**SSD 8636: ENGINEERING & TECHNOLOGY PRECINCT DEVELOPMENT
UNIVERSITY OF SYDNEY, DARLINGTON CAMPUS**

**UNIVERSITY OF SYDNEY
RESPONSE TO SYDNEY WATER SUBMISSION**

RE: The University of Sydney – Engineering & Technology Precinct (ETP) – ECI Peer review
Sydney Water Assets

70% DETAILED DESIGN			
Designed	JH	Project Director	Approved
Drawn	PA	Project	PA
Scale	1:100	Drawing No	1:100
Date	NOV 17	Project Ref	
Sheet	A1	Street	K33-BON-CIV-DRG-00033 1

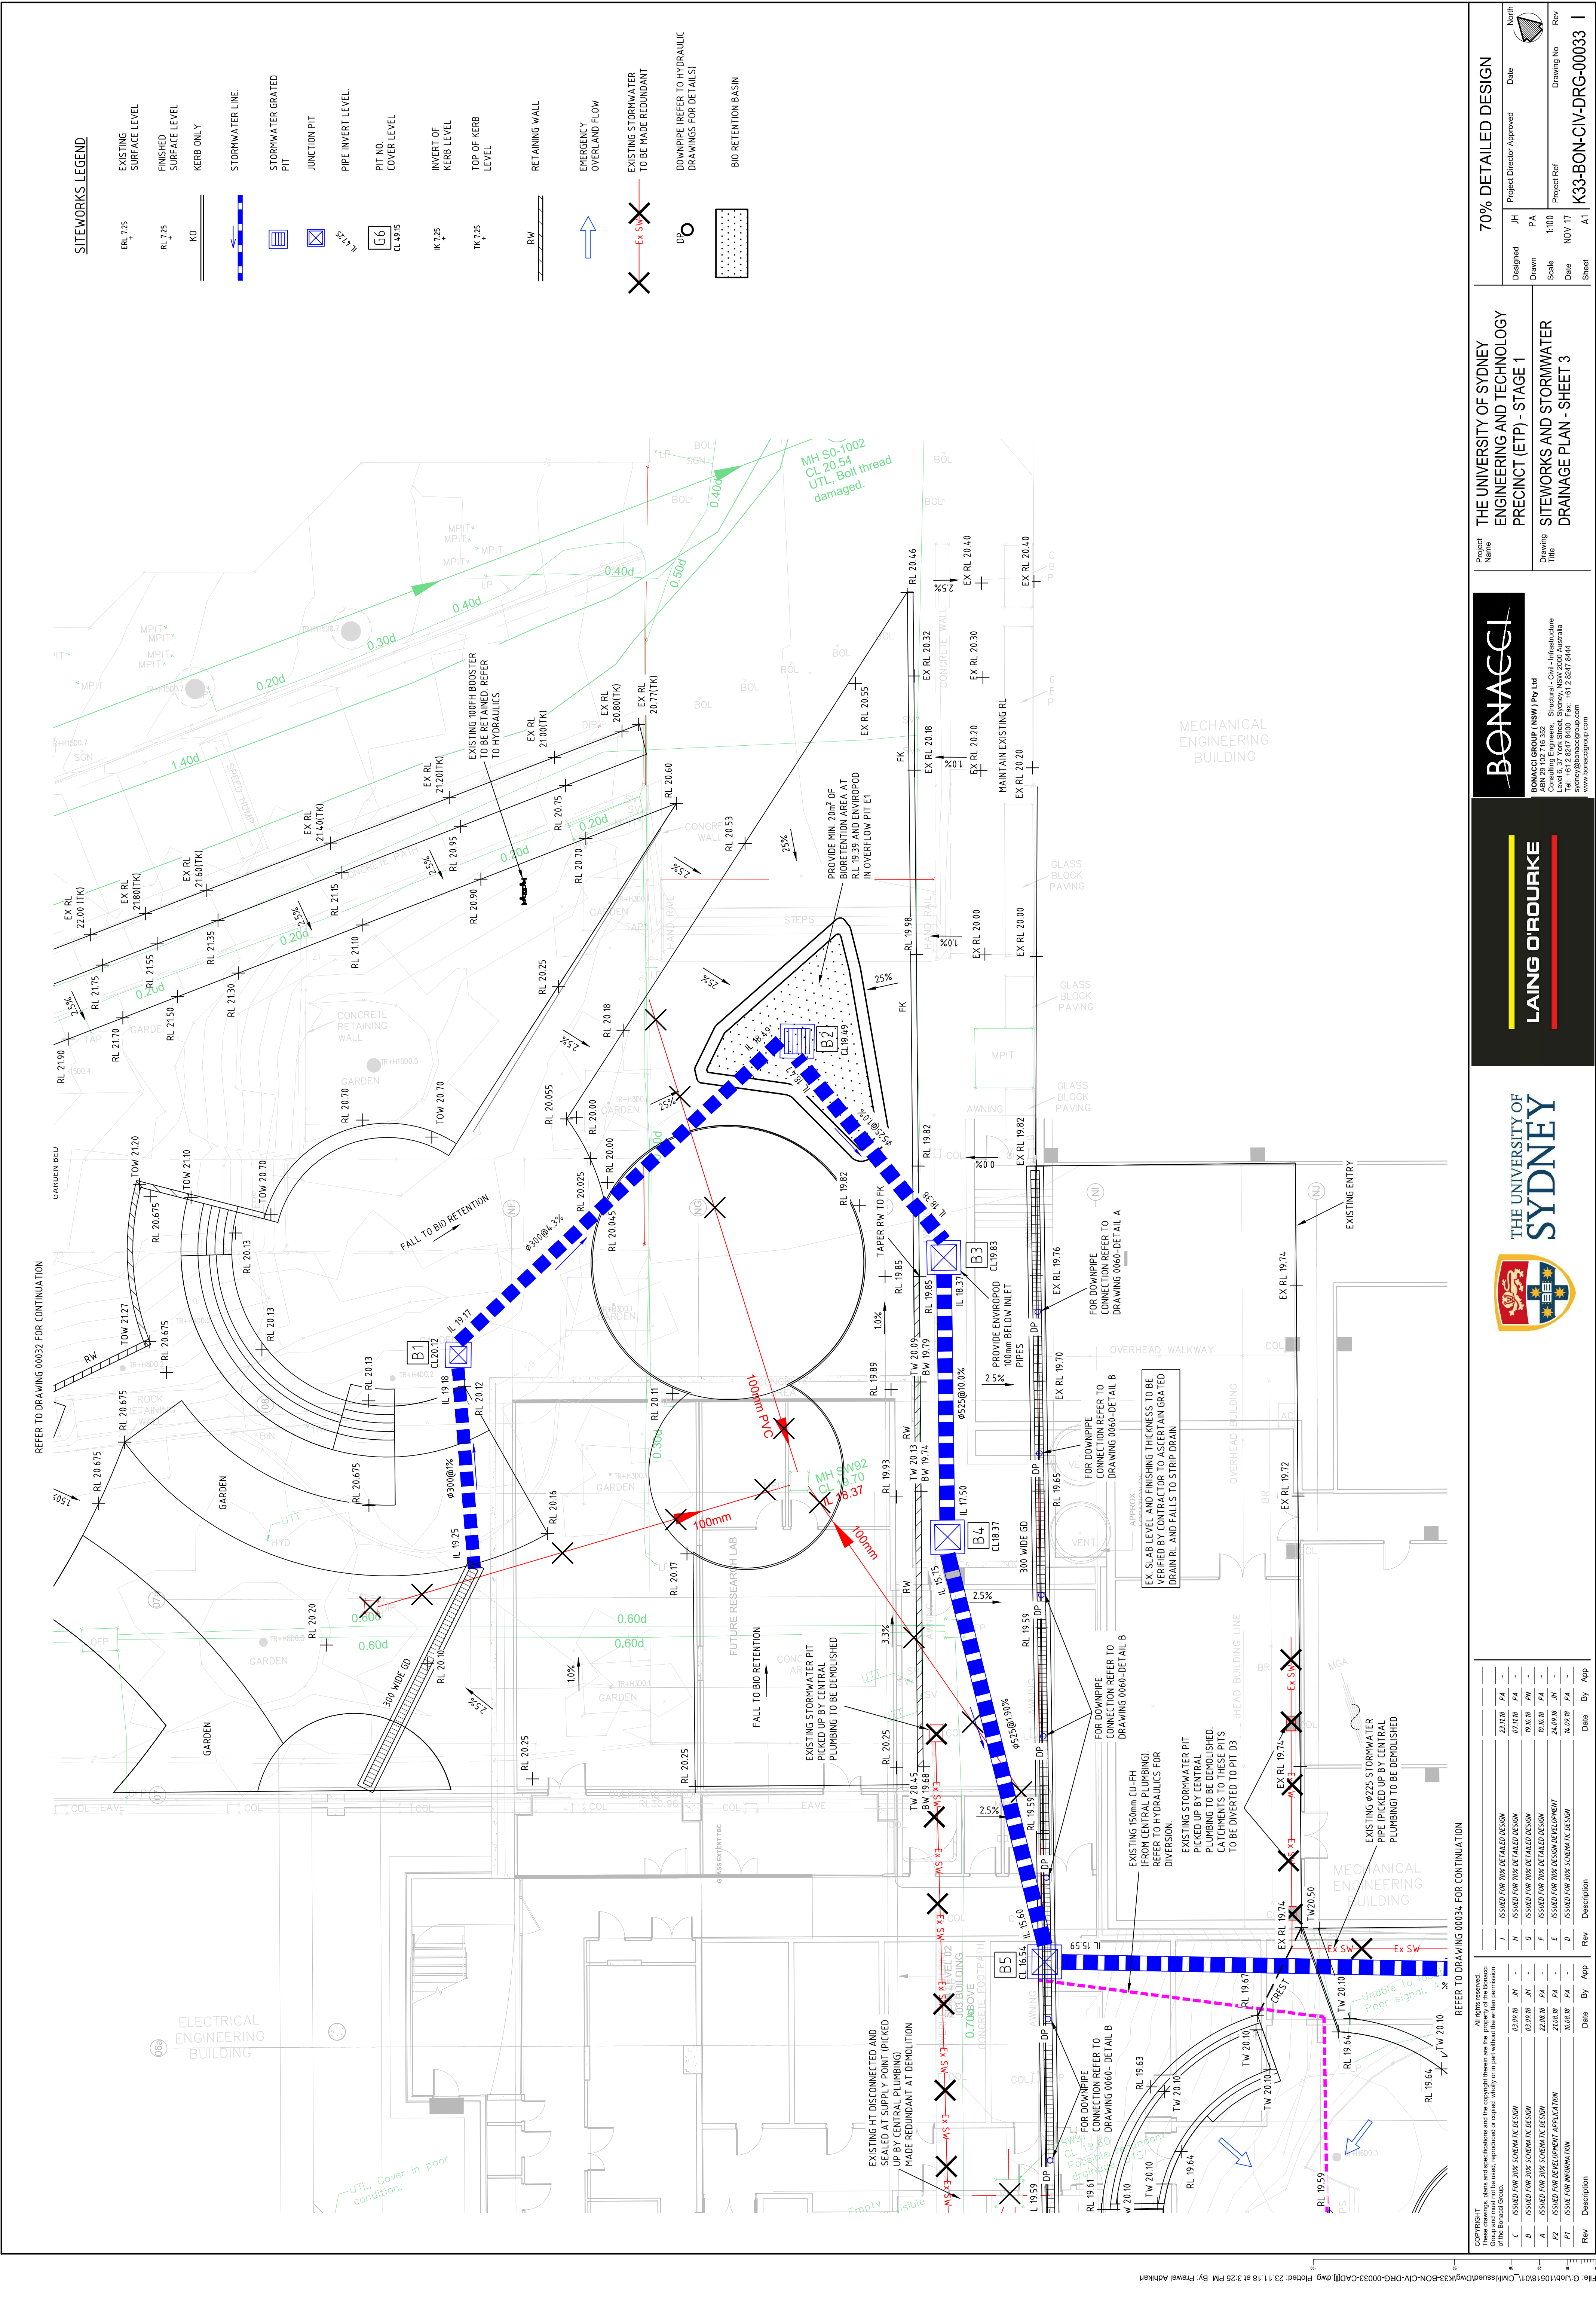
SSD 8636 – ENGINEERING & TECHNOLOGY PRECINCT DEVELOPMENT	
RMS ISSUE	UNIVERSITY OF SYDNEY PROJECT RESPONSE
<p>Sydney Water object to the proposal as it does not meet Sydney Water's building over and adjacent to the stormwater assets requirements.</p> <p>The applicant is required to submit the elevation drawings with the stormwater channel, to ensure that the proposed buildings and permanent structures are 1m away from the outside face of the stormwater channel.</p>	<p>The University attaches a letter by Warren Smith & Partners, dated 27 September 2018, and corresponding plans. The WSP letter concludes the following:</p> <p>“There are no building structures proposed about the stormwater asset except for the small walls and pit outlined above. These works will need to go through the appropriate Sydney Water new connection and building plan approval process to ensure that there are no impacts to existing SWC assets in compliance with Sydney Water code.</p> <p>Warren Smith & Partners has been a Sydney Water Servicing Coordinator for over twenty years and it is our opinion that there will be no non-conformances with Sydney Water guidelines provided appropriate engineering solutions are adopted.”</p> <p>Attachments:</p> <ul style="list-style-type: none">• Letter from Warren Smith & Partners, dated 27 September 2018• Hydra Plan showing DN900 pipe• Site Works and Stormwater Drainage Plan, prepared by Bonacci

We have reviewed the letter received from Sydney Water dated 24th May 2018, which states that the proposed development does not comply with Sydney Water's guidelines for building over and adjacent to stormwater assets. The works proposed to be undertaken are summarised as follows:-

- Creation of a landscaped garden where an existing car park currently sits;
- Reduction of the ground levels by approximately 800mm;
- Provision of low height landscaped retaining walls around the garden and above stormwater asset;
- Provision of a new stormwater pit on the DN900 asset with a new connection.

There are no building structures proposed about the stormwater asset except for the small walls and pit outlined above. These works will need to go through the appropriate Sydney Water new connection and building plan approval process to ensure that there are no impacts to existing SWC assets in compliance with Sydney Water code.

Warren Smith & Partners has been a Sydney Water Servicing Coordinator for over twenty years and it is our opinion that there will be no non-conformances with Sydney Water guidelines provided appropriate engineering solutions are adopted.
